LOCATION 0 Captains Landing

Permit No: 03-0236	Issue Date: APR 09 2003	CBL: 217 B054001
-----------------------	-----------------------------------	---------------------

Proposed Project Description:
Construct 32'x27' 6" Single Family Home w/20'x16' Family Room and 28'x24' Attached Garage

00 Captains Landing - Field Notes - PG 2

2ND FLOOR PLAN
SCALE 1/4" = 1'-0"

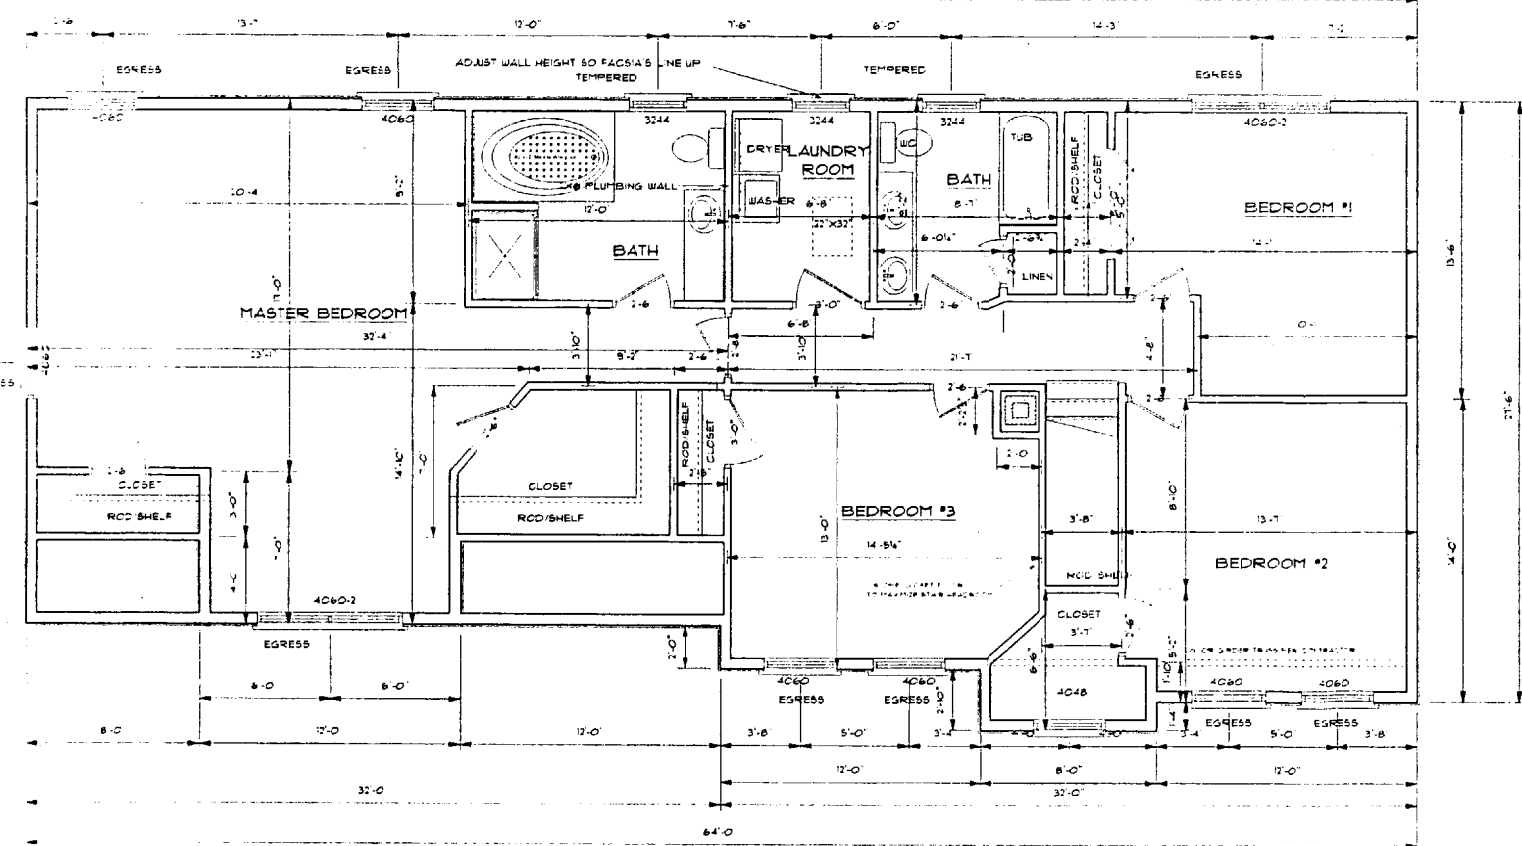
④ Stairs; first to second - first step - Rise 8 1/2" ruff

⑥ Stairs first to second - second door from top - 7 1/4
rise

⑧ Bathroom window needs to be tempered glass see pg 2

~~Item 4 - will be ok at final~~

~~Item 6 - will be ok on final~~

Item 8 - Tempered glass ordered - will be ok @ final
